City of Albuquerque

RE: TOM HANEY OFFICE ADDITION
(H-22/D24) RECEIVED NOVEMBER 21, 1986

RE: REVISED DRAINAGE PLAN FOR AN ADDITION TO THE OFFICE OF
THOMAS HANEY (H-22/D24) ENGINEER'S STAMP DATED NOVEMBER 5,
1986

RE: DRAINAGE PLAN FOR AN ADDITION TO THE OFFICE OF THOMAS HANEY
(H-22/D24)

SHEET TITLE:
GRADING AND DRAINAGE PLAN

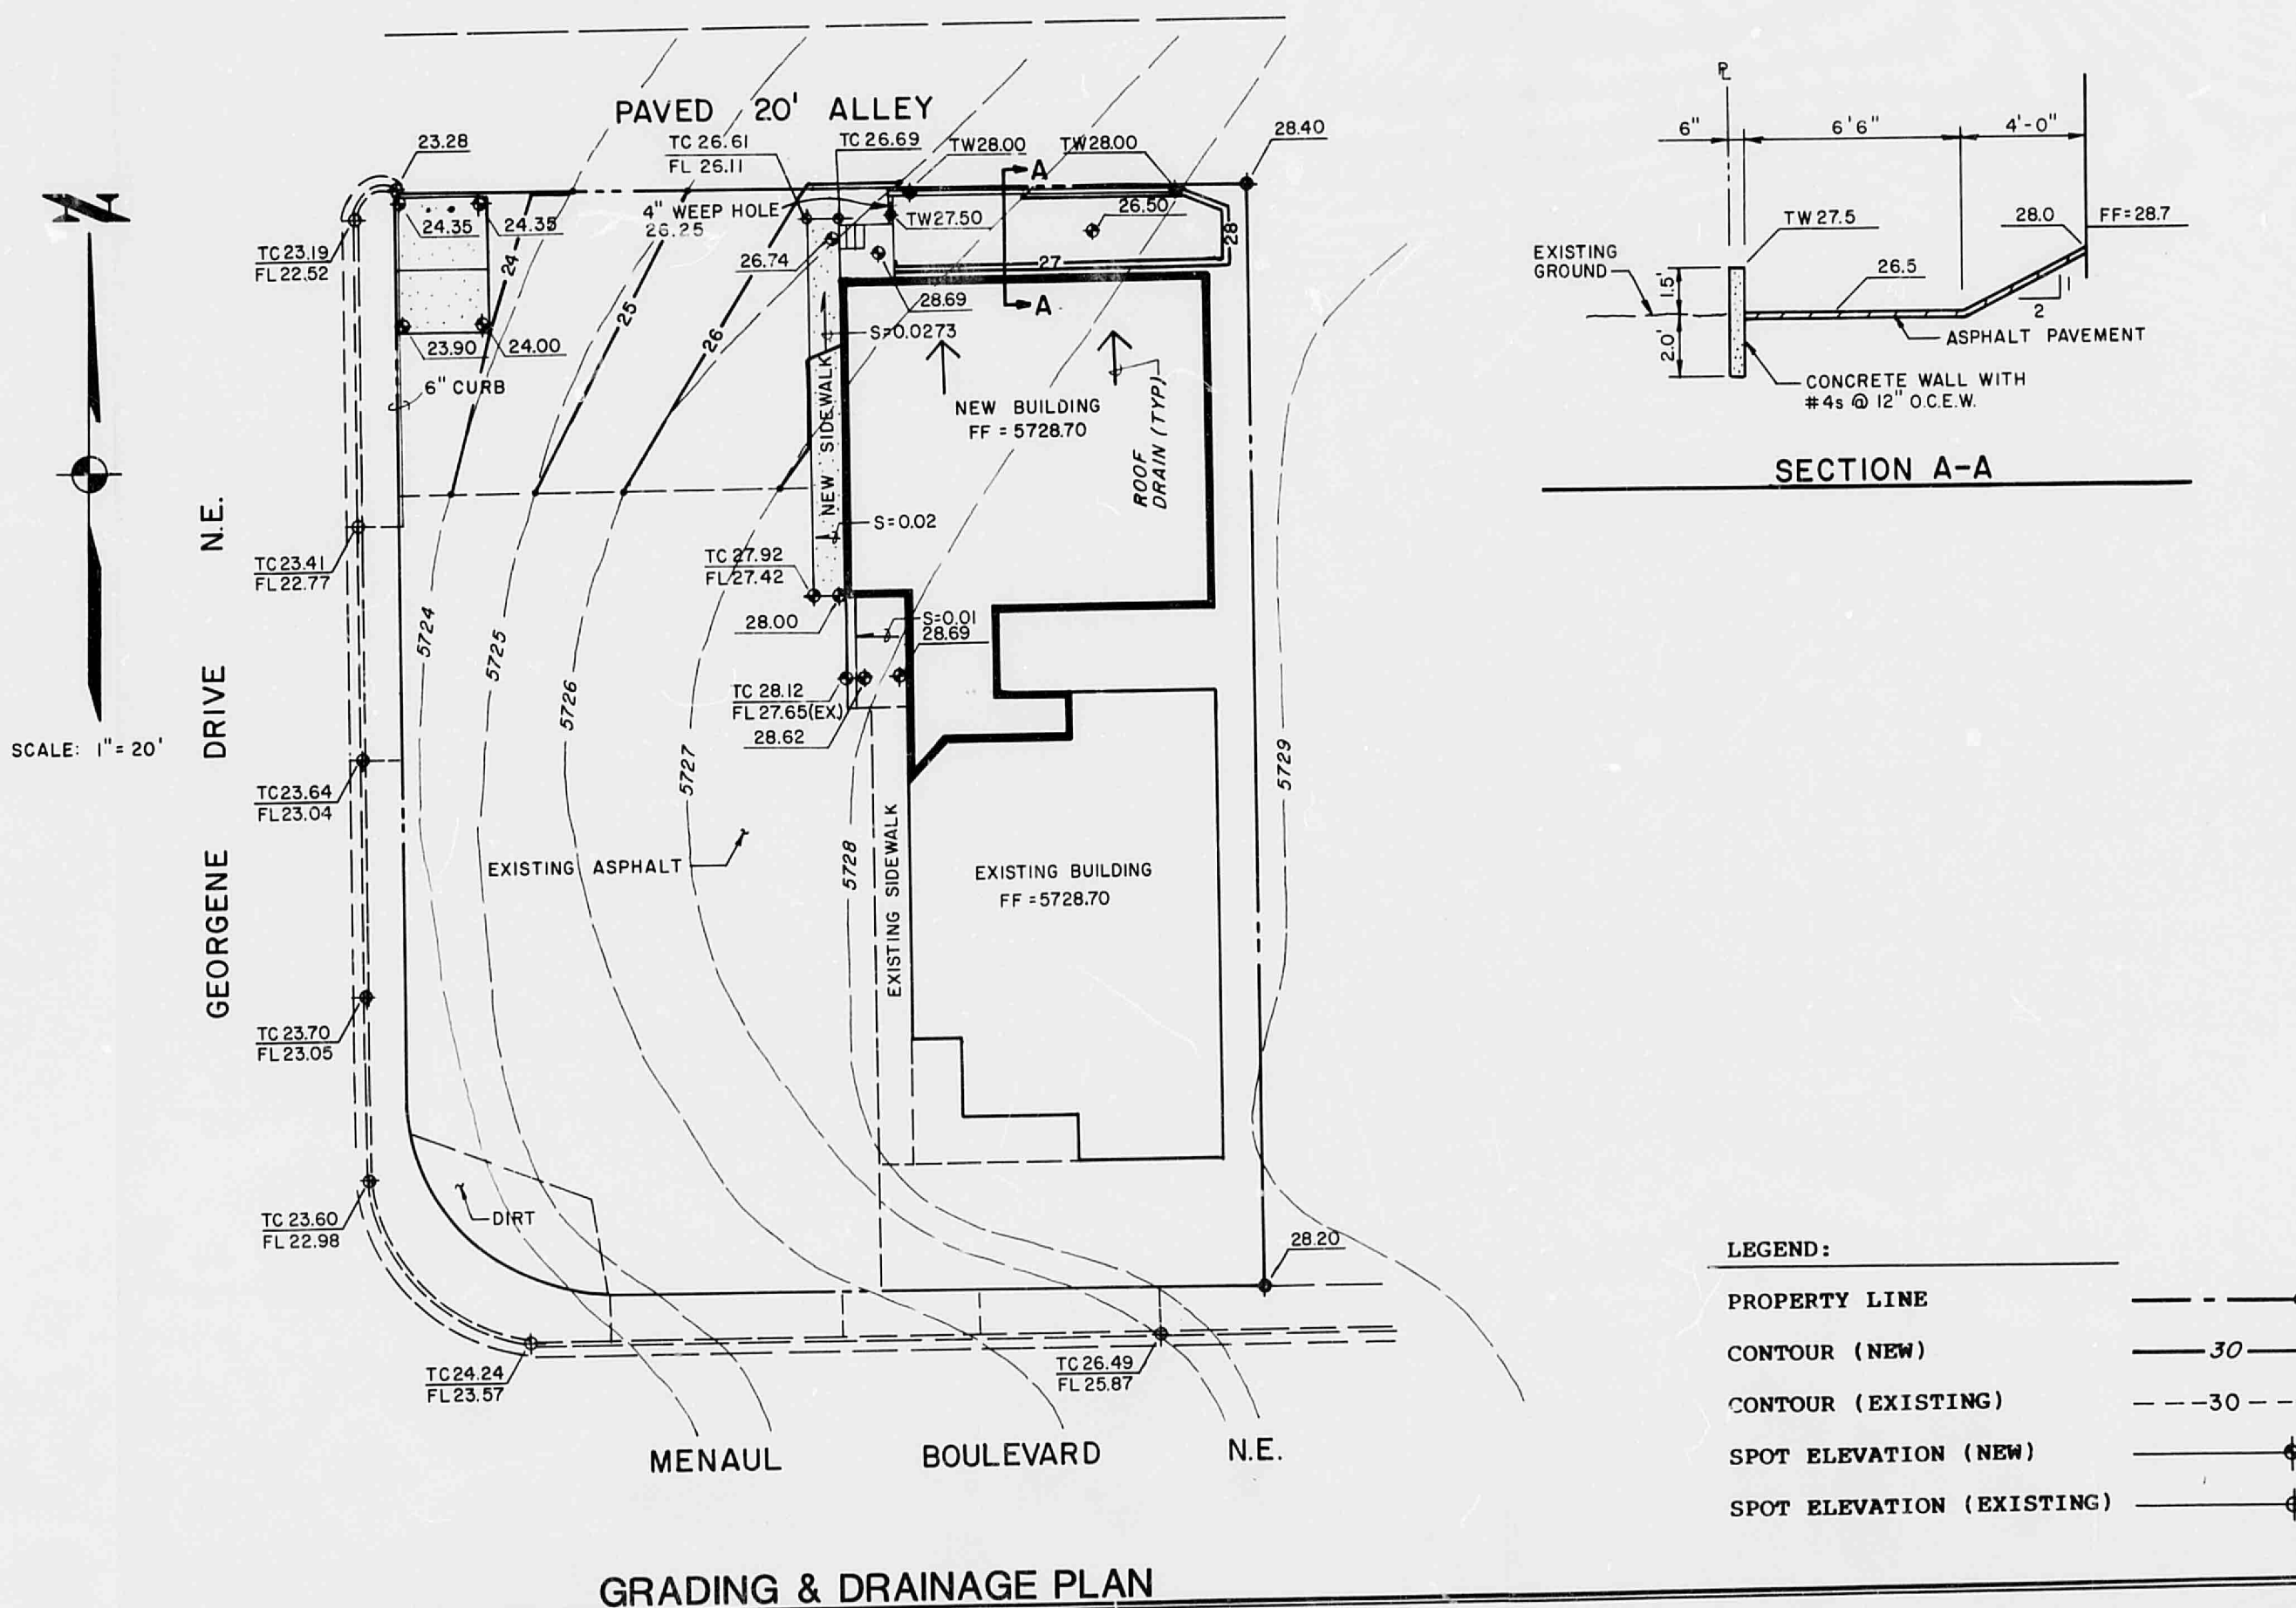
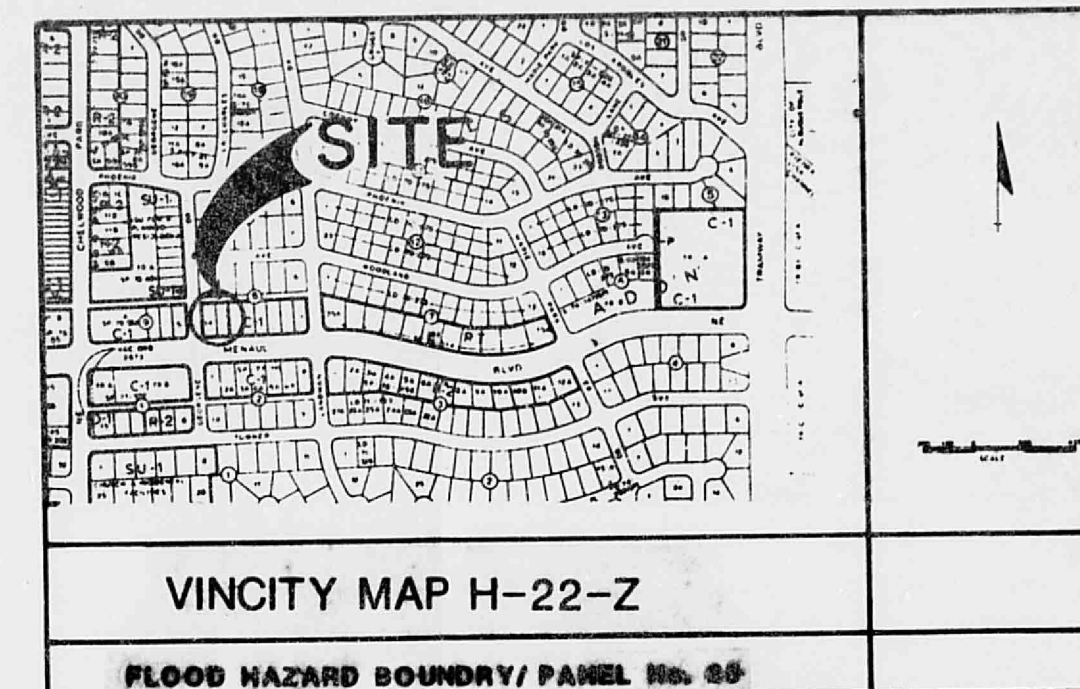
1. Under proposed condition: ponds "North" of proposed building is the correct statement, please change.
2. S.O. #19 will be required for the 4" release pipe into the existing paved alley. Please include with resubmittal. Include Notice to Contractor from S.O. #19 Form and reference the construction detail.
3. Please advise your client to request inspection from Rick Duran at 764-1699.
4. Building Permit cannot be released until covenant, replat, or easement is submitted for cross-lot line drainage.

1. Your contours show that some of the developed runoff will be routed over the public sidewalk. Developed runoff must be routed thru an approved curb cut.
2. How do you intend to protect the foundation from the pond water?
3. Our existing records show that no final inspection or approval has ever been issued for the existing building. The building must be brought into compliance per the approved drainage plan, dated May 21, 1981.
4. A drainage covenant for flows across lot lines is required.

1. Plan drawing size 24" x 36".
2. Location and direction of roof drains.

1. Correction was made to the drainage report to reflect that the detention pond is on the north side of the site.
2. As per our telephone conversation, the sidewalk will be stopped short of the alley to allow developed runoff to flow across the parking lot. This change should relieve us from the S.O. #19 requirement.

In order to prevent developed runoff from flowing over a public
sidewalk, a 6" curb will be installed directing flows to the
existing public alleyway located immediately north of the site.

The foundation of the building will be protected by lining
the holding pond with a 2" thick asphalt pavement.

Our office has transferred the drawing onto a sheet size of
24" X 36".

Roof drains have been located on the plan.
